DRB Application No 07DRB-70223 (P&F)  
Project Name: LOT 10-A-1 WASHINGTON BUSINESS PARK  
Agent: BOHANNAN HUSTON INC

**ITEM # 14**

**PROJECT # 1006788 APPLICATION # 07-70223**

**RE: Lot 10-A-1, Washington Business Park/plat**

PLAT OF  
**LOT 10-A-1**  
**WASHINGTON BUSINESS PARK**  
(A REPLAT OF TRACTS B-3-A-1 & LOT 10-A  
WASHINGTON BUSINESS PARK)

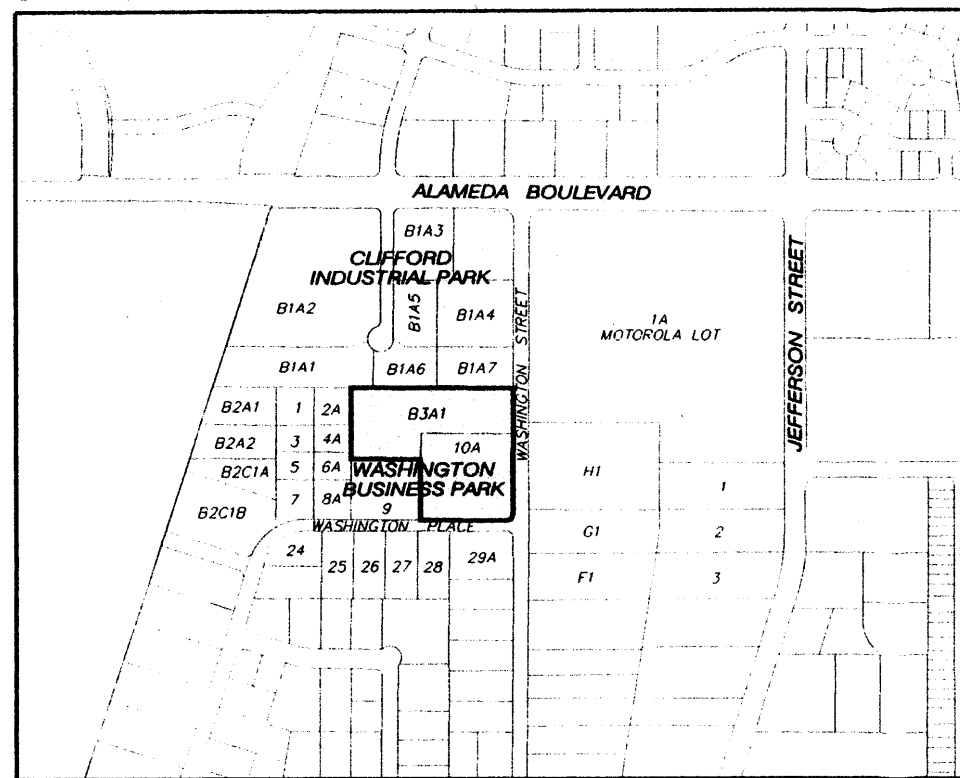
Be advised that any plats approved by DRB must contain the following language from the City Subdivision Ordinance:

Section 14-14-4-7(B) "No property within the area of requested final action shall at any time be subject to a deed restriction, covenant, or building agreement prohibiting solar collectors from being installed on buildings or erected on the lots or parcels within the area of proposed plat. The foregoing requirement shall be a condition to approval of this plat or site development plan for subdivision."

Once this language is added, Planning has no objection to the requested replat.

Planning will take delegation of the plat for the addition of this language, AGIS dxf approval.
